**REQUEST**

Current Zoning: N1-A (neighborhood 1-A), CG (general business)  
Proposed Zoning: I-1(CD) (light industrial, conditional)

Approximately 3.55 acres bound by the east of side of Lakebrook Road, north side of Centergrove Lane, west side of Sam Wilson Road, and south side of Interstate 85.

The petition proposes to allow the development of convenience store with gas and diesel fuel pumps along with accessory and incidental uses associated with the principal use. The site is currently undeveloped.

SHEET TITLE:  
 REZONING PLAN  
 PETITION 2022-216

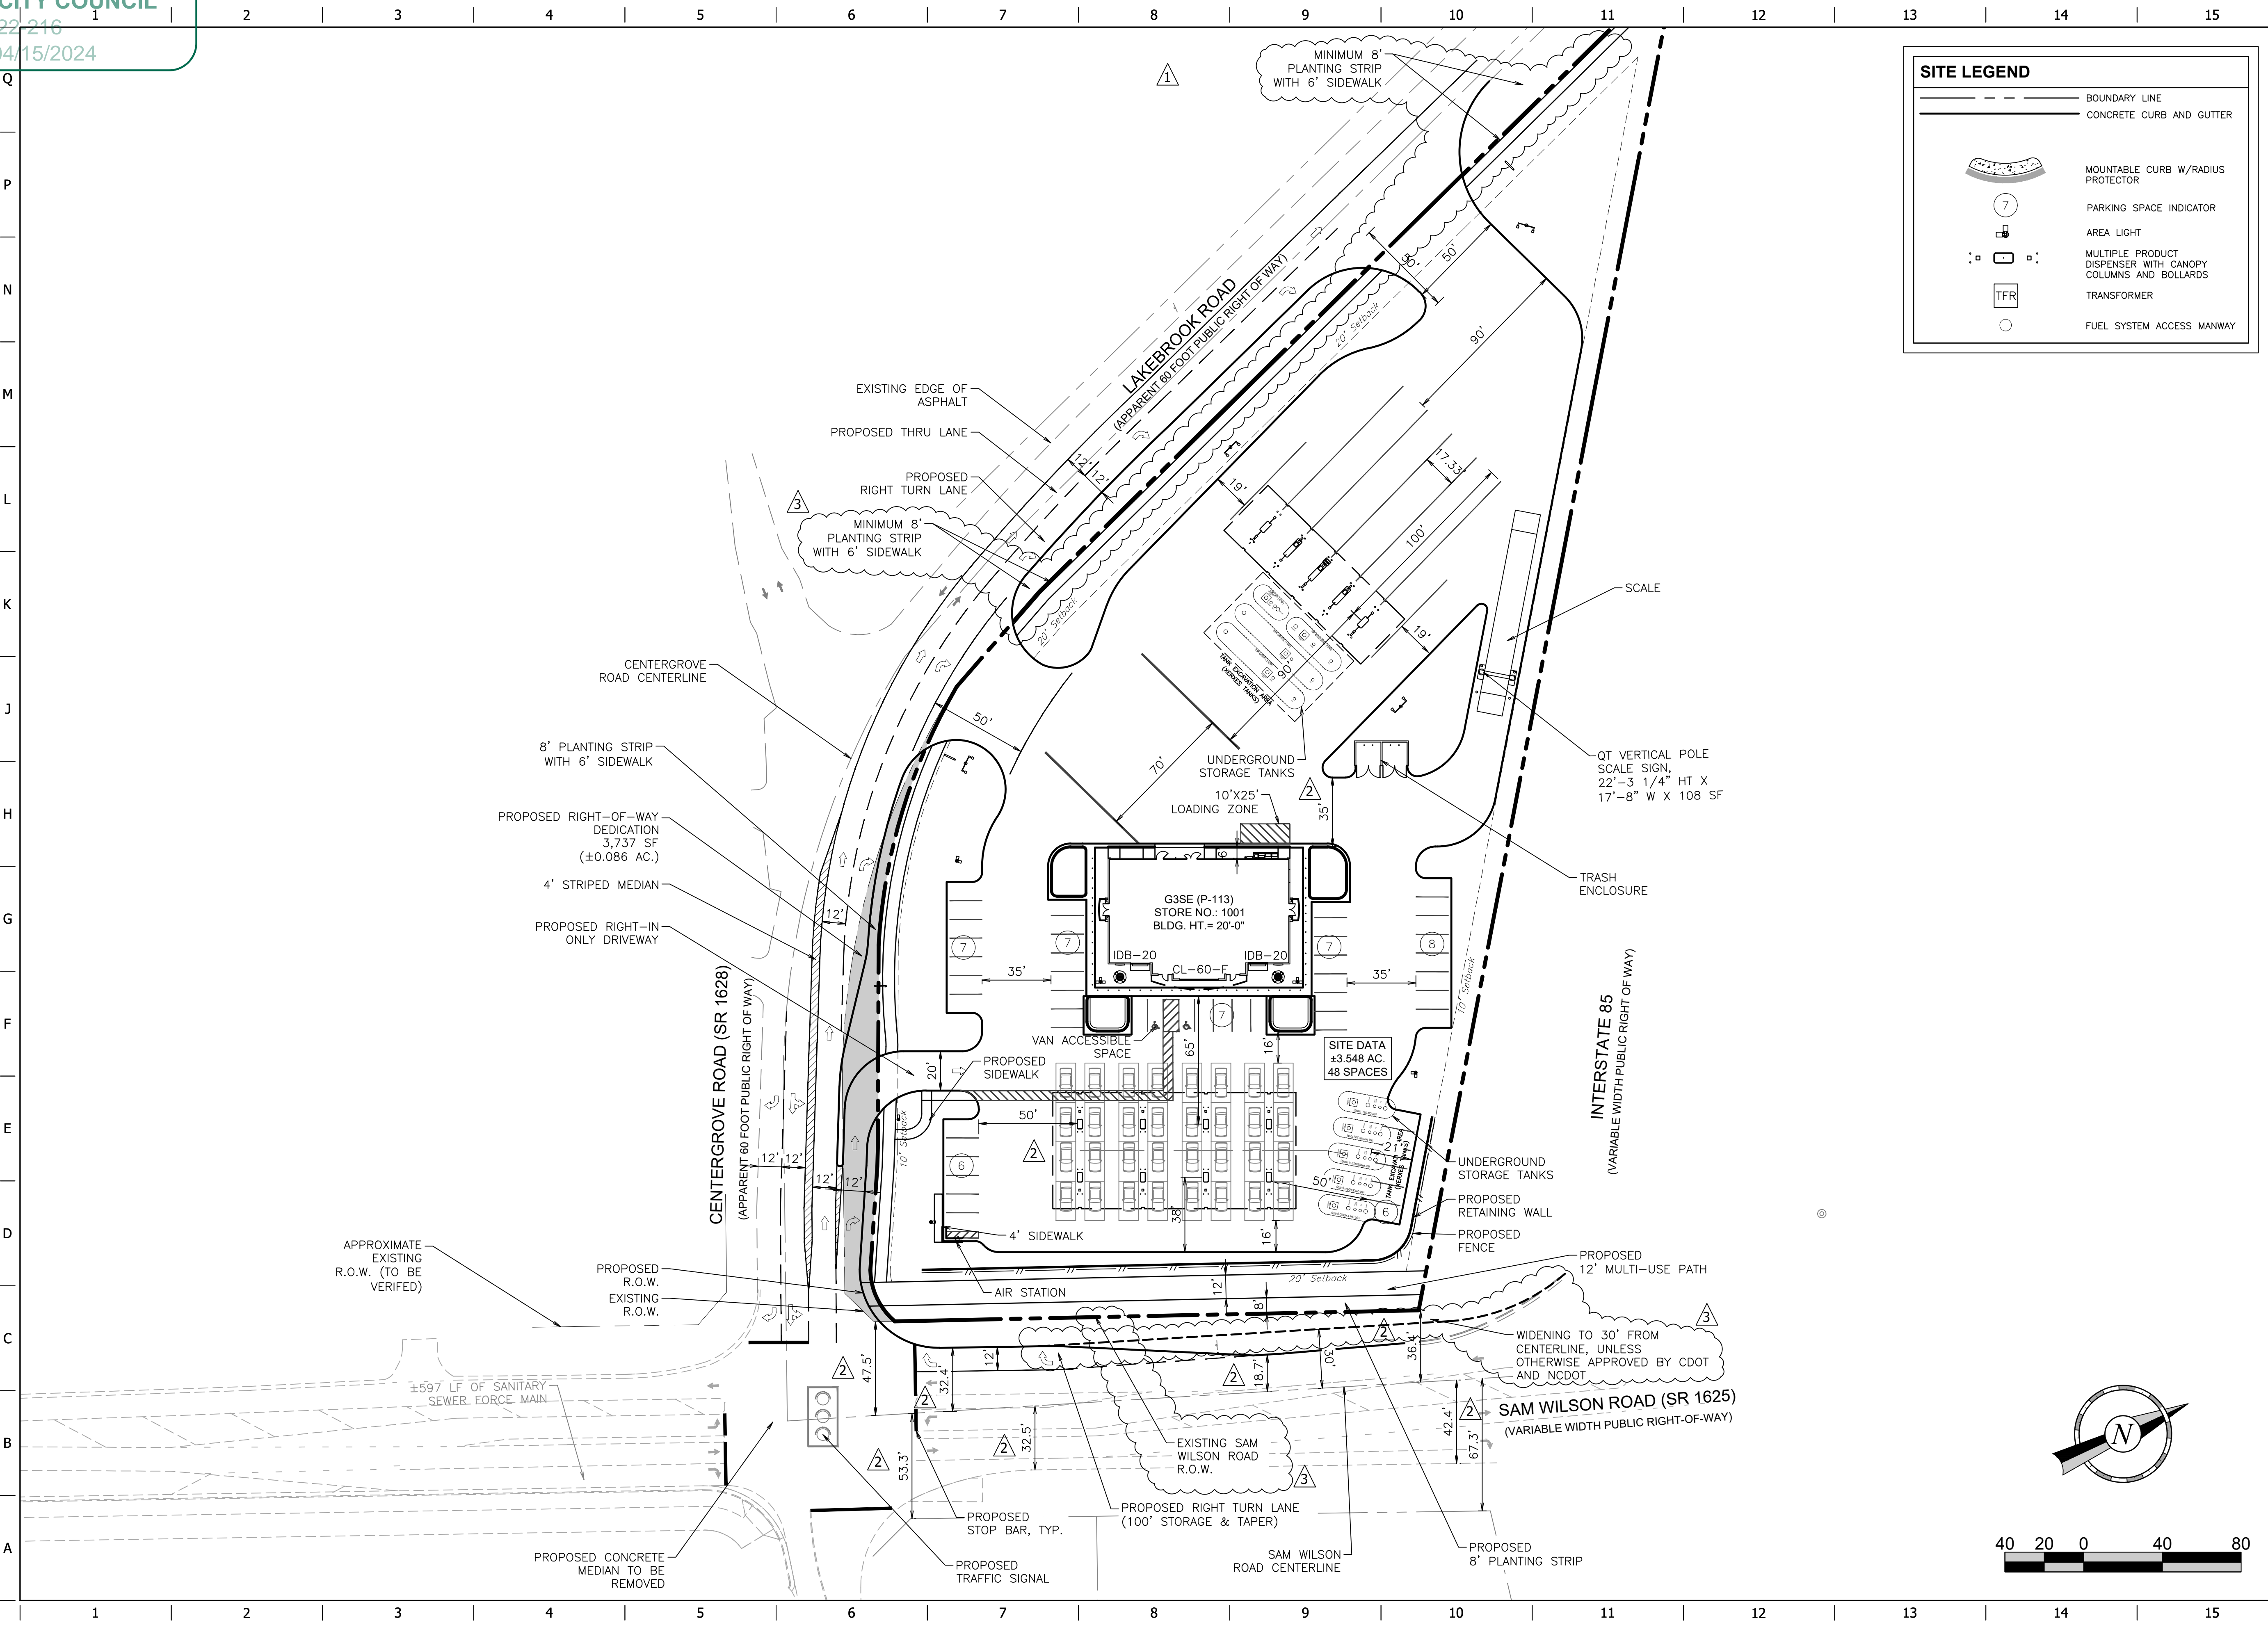
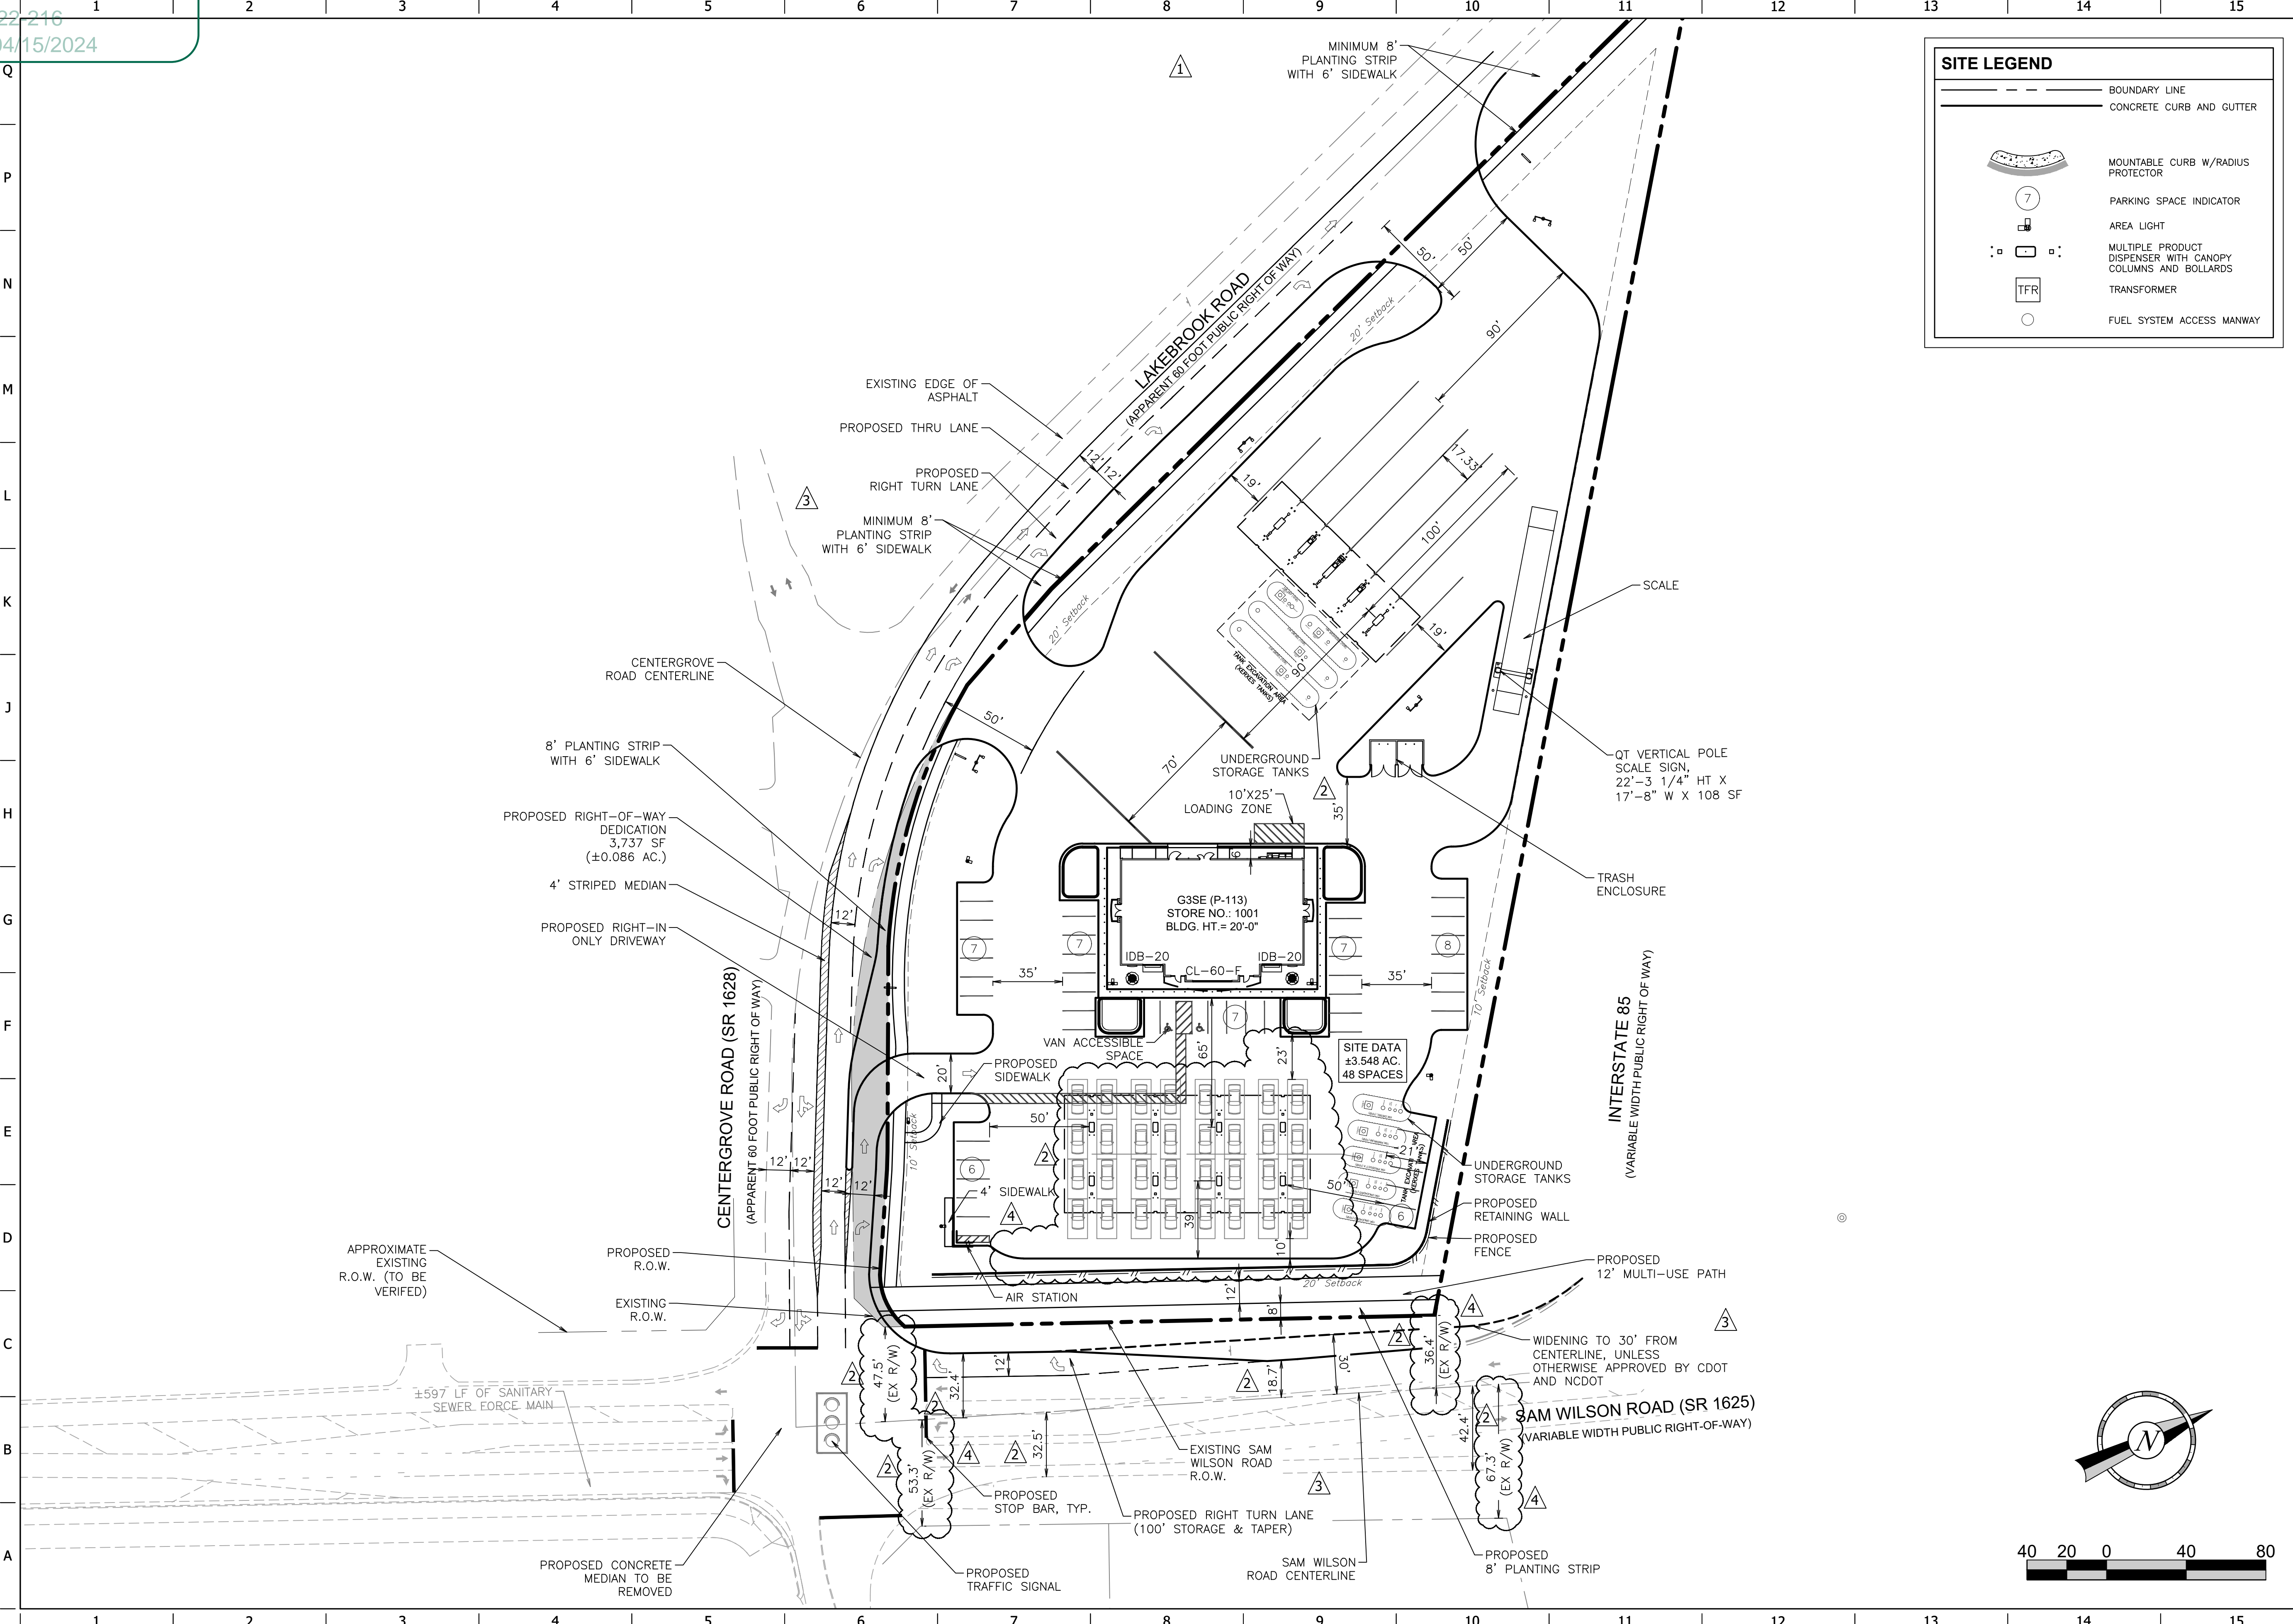
- The site is located on the north side of Centergrove Lane, a State-maintained local street, west of Sam Wilson Road, a State-maintained minor thoroughfare. A Traffic Impact Study (TIS) is required for this site and was approved by CDOT on 11-27-2023. Site plan and/or conditional note revisions are needed including labeling and dimensioning right-of-way/curb and gutter elements from centerline.

1. ~~Location of curb and gutter to be moved to 30 feet from roadway centerline to accommodate the Charlotte Streets Map with a roadway typical section of a 4+ avenue with a 12-foot multi-use path. Label and dimension curb and gutter 30 feet from roadway centerline on Sam Wilson.~~ **ADDRESSED**

2. ~~Revise site plan and conditional note(s) to commit to dedicate 35 feet of right of way from the road centerline on Sam Wilson Road. The site plan shall label and dimension the right of way from the road centerline. Label and dimension right of way from roadway centerline on Sam Wilson.~~ **ADDRESSED**

3. ~~Revise site plan to clearly show and label where existing right of way is and proposed right of way.~~ **ADDRESSED**
4. ~~Revise site plan and conditional note(s) to construct 8-foot planting strips and 6-foot sidewalks on Centergrove Lane and Lakebrook Road and a 12-foot multi-use path on Sam Wilson Road. The site plan shall label and dimension both items from the back of curb and gutter or edge of pavement. Add conditional note The entire facility must be outside of the right of way and within a public access easement. Add conditional note committing to construction and maintenance of the 6-foot sidewalk on Centergrove Lane and the 12-foot multi-use path on Sam Wilson Road. Add conditional committing to maintenance of 6-foot sidewalk on Centergrove Lane.~~ **ADDRESSED**
